To The Secretary of State of Energy Security and Net Zero and to whom ever else is concerned in the re-determination of the Aquind proposal.

In the re-determination of this proposal by the SoS, I would suggest that nothing has changed, in the intervening time that affects that original decision, to again refuse the application by Aquind.

Compulsory Aquisition Hearing 1 – Appendix 1
- Exhibit 15 Cross-section showing the typical
arrangement of the construction corridor
across Milton Common

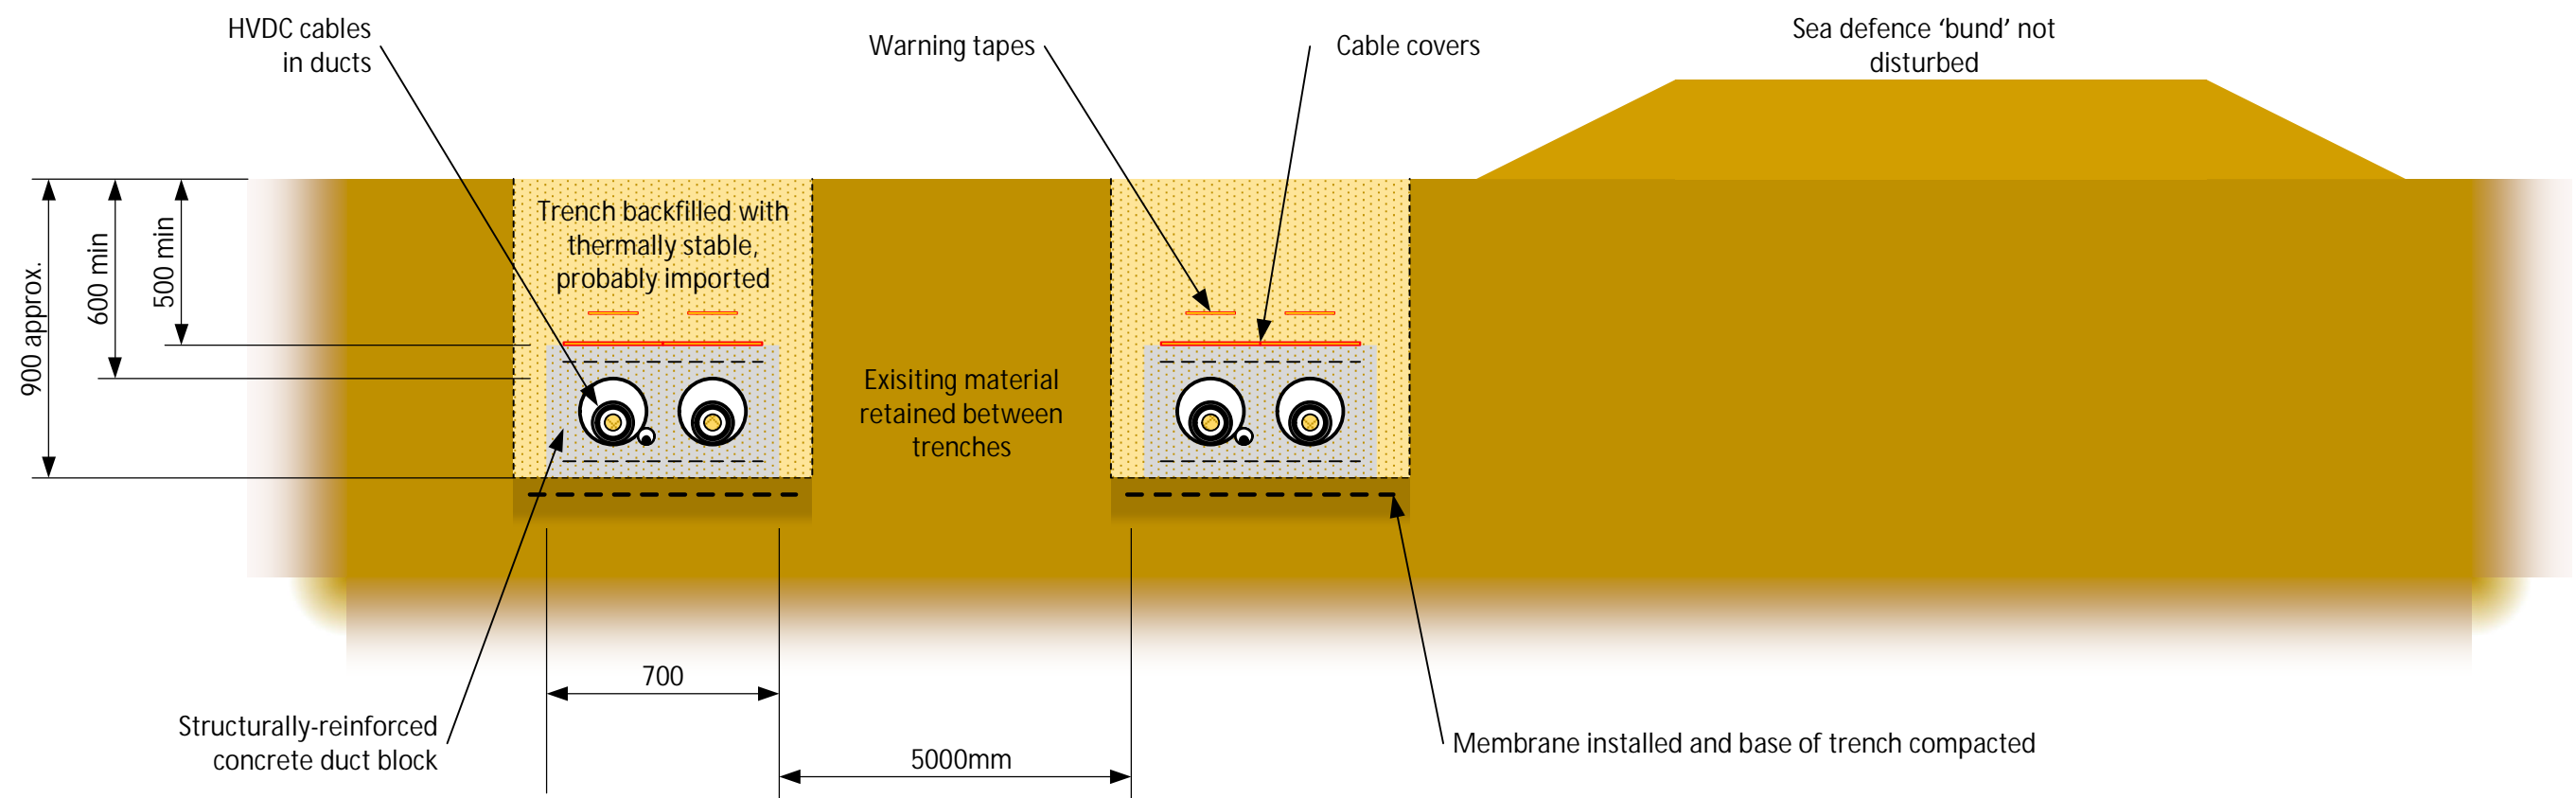
I would like to highlight that no one has a single clue as to what is buried underneath Milton Common. This is clearly why Aquind still, after all this time during the process, maintain a requirement in the DCO for a 3 option route across the Common using a combination of any of the 3 routes. They do not know what they will encounter in their open trenching. The protective clay cap, historically installed when the common was created, will be disturbed. It is a Pandora's box for people's health, habitat, wildlife and air quality.

With regards to the 3 options over Milton Common, the most eastern option route, running north to south through the Common, appears according to the applicants land plans (submitted at deadline 7) to disturb or certainly impact upon the relatively recently installed secondary sea defence bunds. These were installed around the Langstone Harbour foreshore and on the land side the 3 lakes situated on Milton Common. I think this route needs to be actually defined by the applicant prior to any re-determination decision being made. Will it affect any of the 3 lakes or their water quality? Will it affect the ongoing coastal defence construction? There is no room on Milton Common for a trial and error carve up on it, in what the applicant called 'optioneering'.
